Rezoning Transportation Analysis

Petition Number: 2020-200

General Location Identifier: 14510317 and 14510318

Date	Description
12-28-2020	First Review (KP)
01-21-2021	Second Review (KP)

RZ-1.0

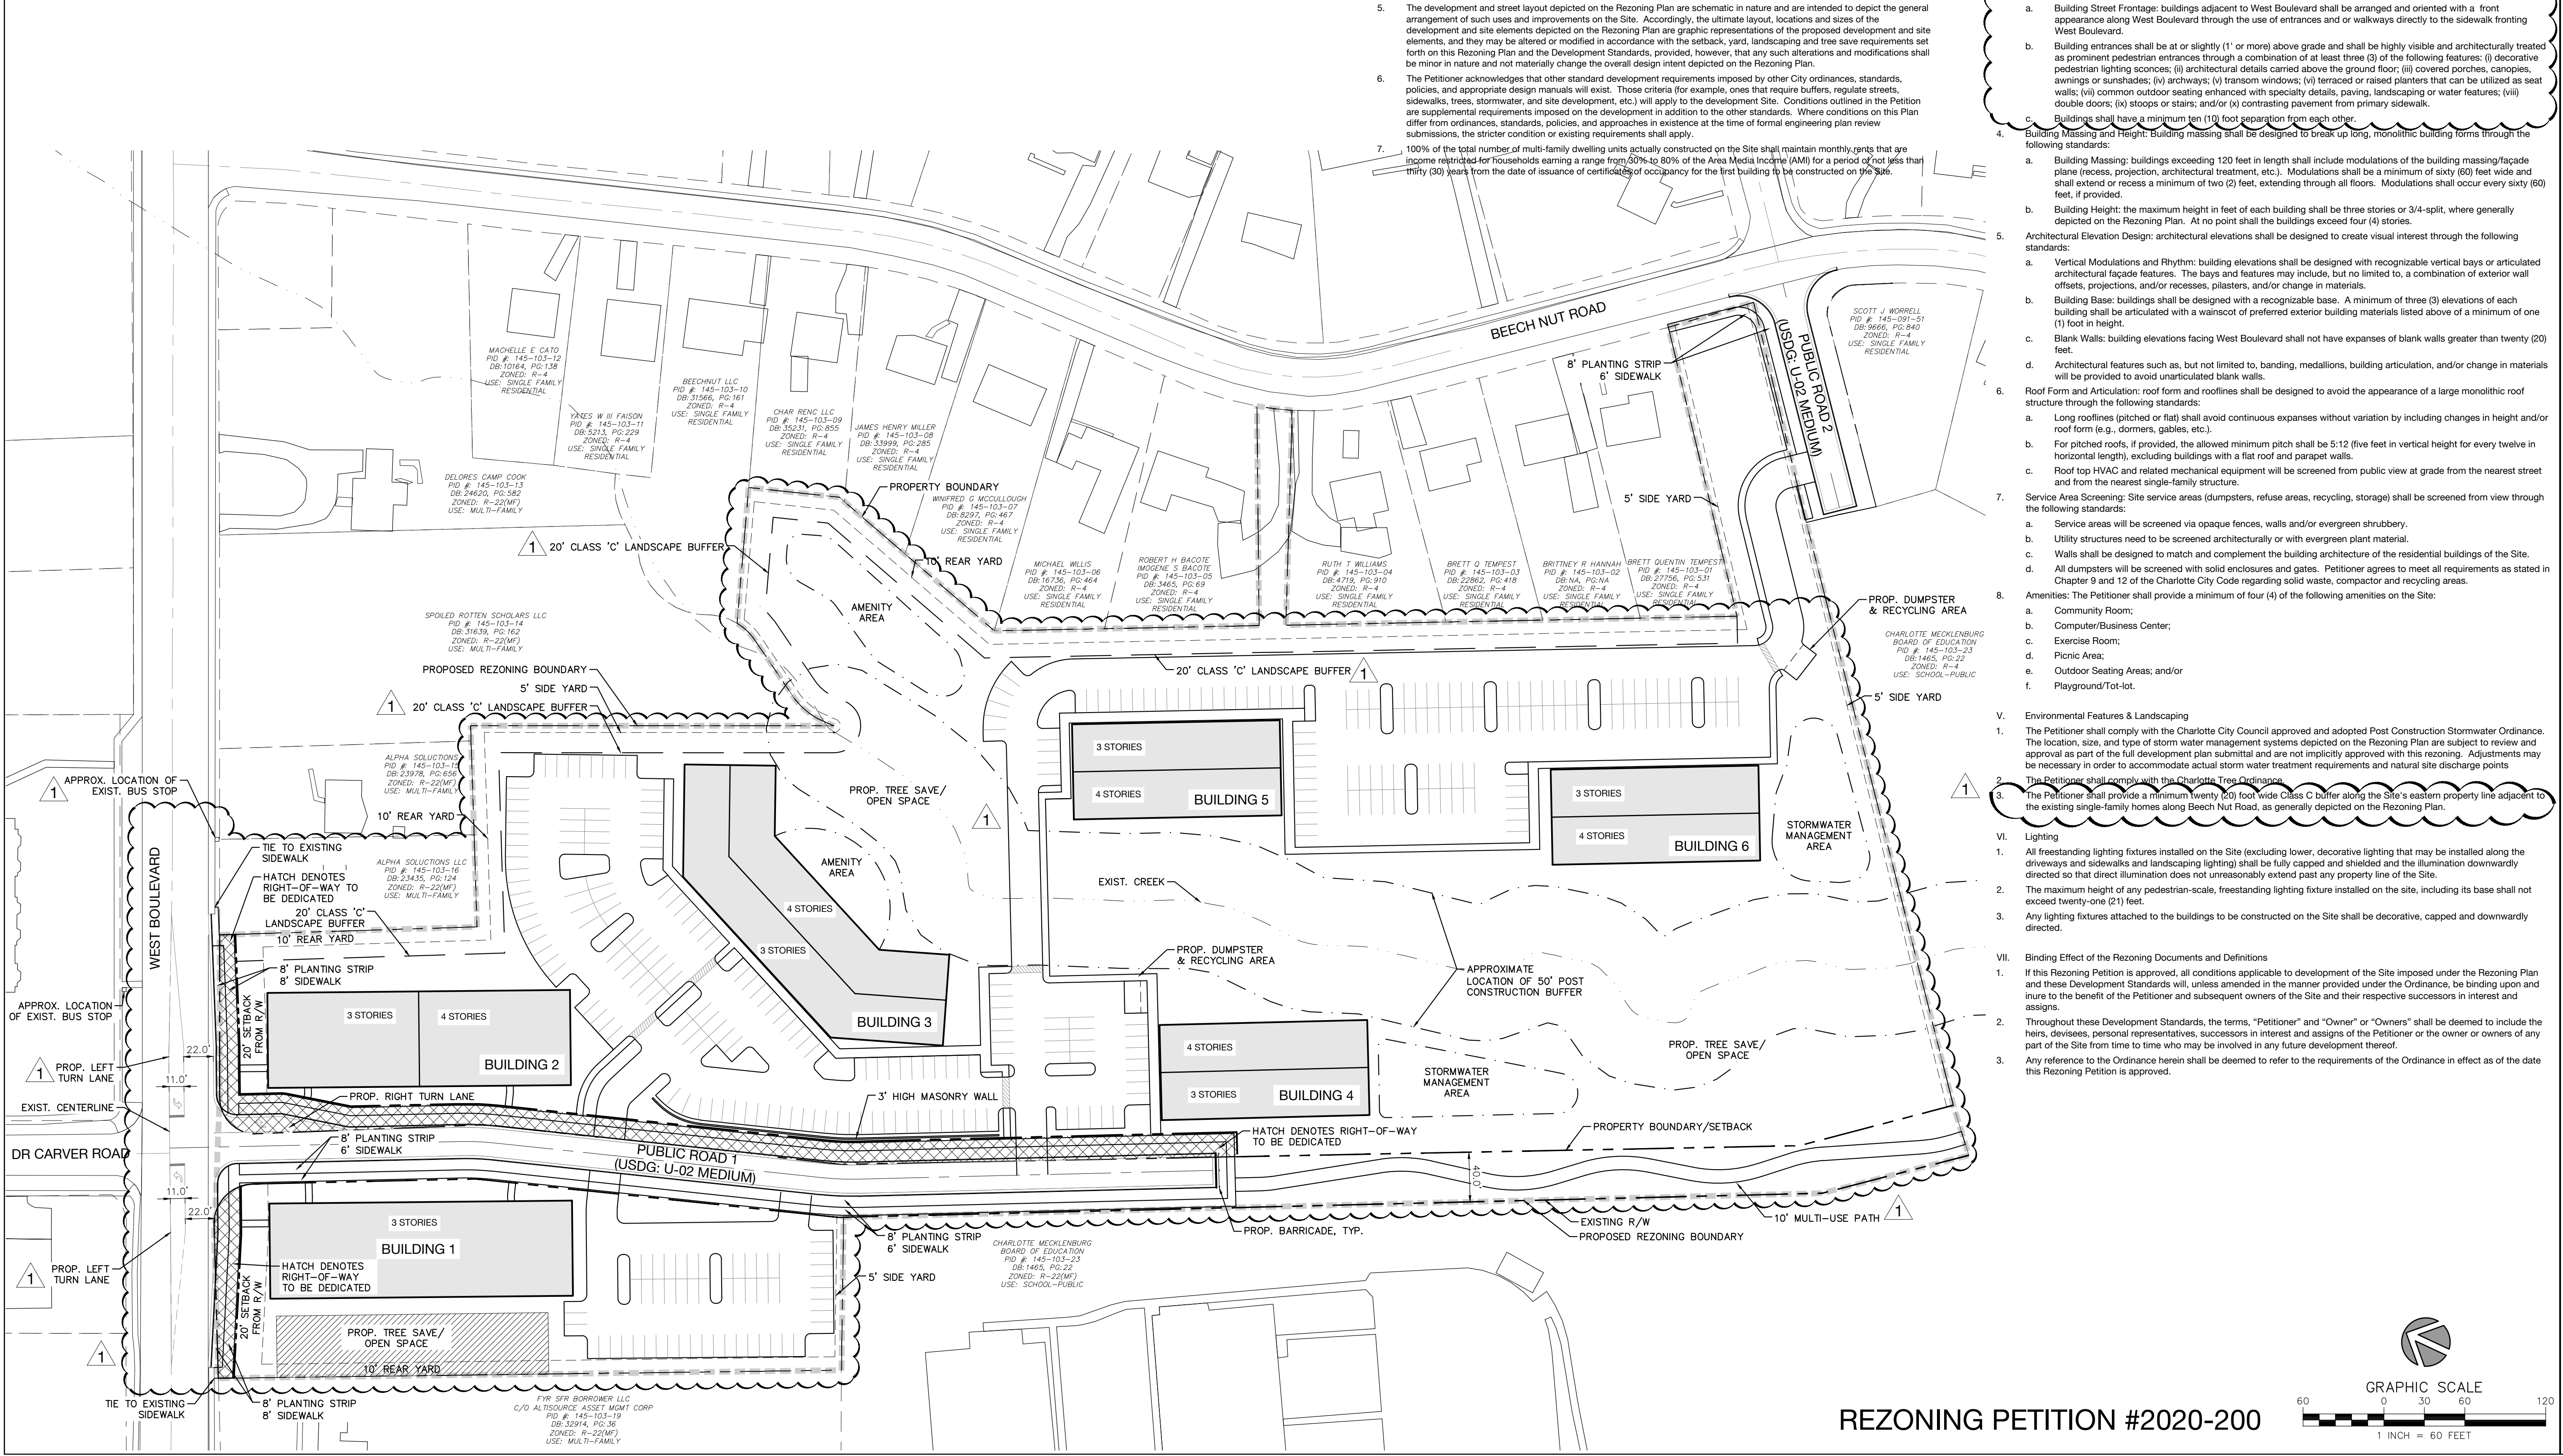
- a. **West Boulevard:** Relocate the existing curb and gutter to the future location at 38-feet from the road centerline to back of curb, to accommodate a future 4-lane Avenue road cross section with buffered/separated bike lanes and left-turn lanes.

Label and dimension the curb and gutter from the centerline for each road on the site plan.

- a. **West Boulevard:** Revise site plan and conditional note(s) to commit to dedicate 56-feet of right-of-way from the road centerline, to provide 2-feet behind the proposed sidewalk.
- b. **Paper Right-of-way:** Revise the site plan and conditional notes to dedicate 56-feet of total right-of-way, 28-feet of right-of-way from the paper right-of-way centerline.

Label and dimension the right-of-way from the centerline of each road on the site plan.

- 4. Revise site plan and conditional note(s) to commit to construct an 8-foot planting strip and 8-foot sidewalk on West Boulevard, as well as an 8-foot planting strip and 6-foot sidewalk on Proposed Public Roads 1 and 2, unless otherwise required by the Subdivision Ordinance. **The site plan needs to label and dimension both items from the road centerline.**

- 5. In accordance with the Charlotte BIKES Plan, revise the site plan and conditional notes by committing to the construction of an 8-foot buffered bike lane along the site's West Boulevard frontage. **The site plan needs to label and dimension the buffered bike lane from the road centerline.**

6. Revise the site plan and conditional notes by committing to the construction of two left-turn lanes, on West Boulevard, and providing left turning movements onto Dr. Carver Road and Proposed Public Road 1. Additionally, signal modifications will be required to accommodate the additional left-turn lanes and the addition of Public Road 1 as the fourth leg of the intersection. These improvements will be required to be built to NCDOT Standards.

Update to Comment as a result of the 01-12-2021 Site Plan: A conditional note committing to the left-turn lanes and signal modifications needs to be included. Additionally, include a conditional note that commits to coordinating with NCDOT, during permitting, to determine storage lengths, tapers, and any other potential lane striping modifications.

Update to Comment as a result of the 01-12-2021 Site Plan: Please show lane striping on Public Road 1. Include turn lane striping as well.

9. Revise the site plan and conditional notes by committing to coordinate with Charlotte-Mecklenburg Schools (CMS) to provide a pedestrian connection/access to the Irwin Creek Greenway. The ICG currently has a trailhead located within the adjacent property of the Berringer Academic Center.
Update to Comment as a result of the 01-12-2021 Site Plan: Include the conditional note to coordinate with CMS to make the connection to the Irwin Creek Greenway Trailhead.

10. Revise the site plan and conditional notes by committing to coordinate with CATS, during permitting, to make improvements to the existing bus stop on West Boulevard. The site plan needs to show the existing bus stop.
